# CITY OF ALBUQUERQUE

**Re: Ladera Self Storage-2100 Ladera Rd NW  
Erosion and Sediment Control Plan  
Engineer's Stamp Date 9-19-18 (H09E001F)**

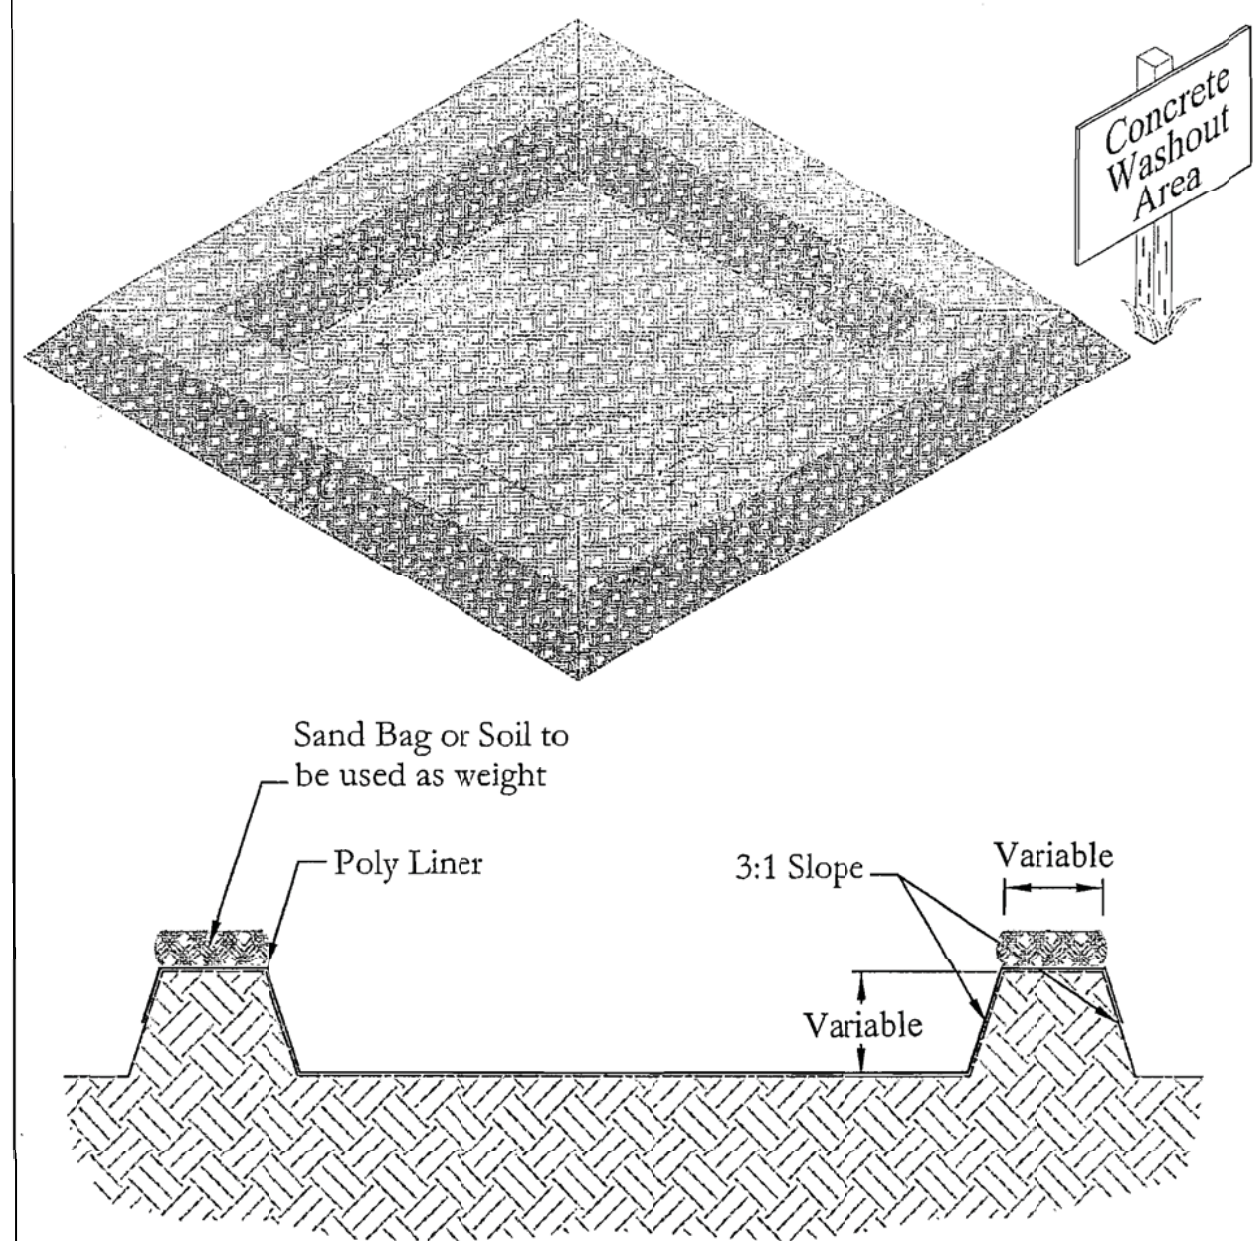
Note: There appears to be a CMU wall along most of the southern boundary. Silt fence may not be necessary in the location of the wall.
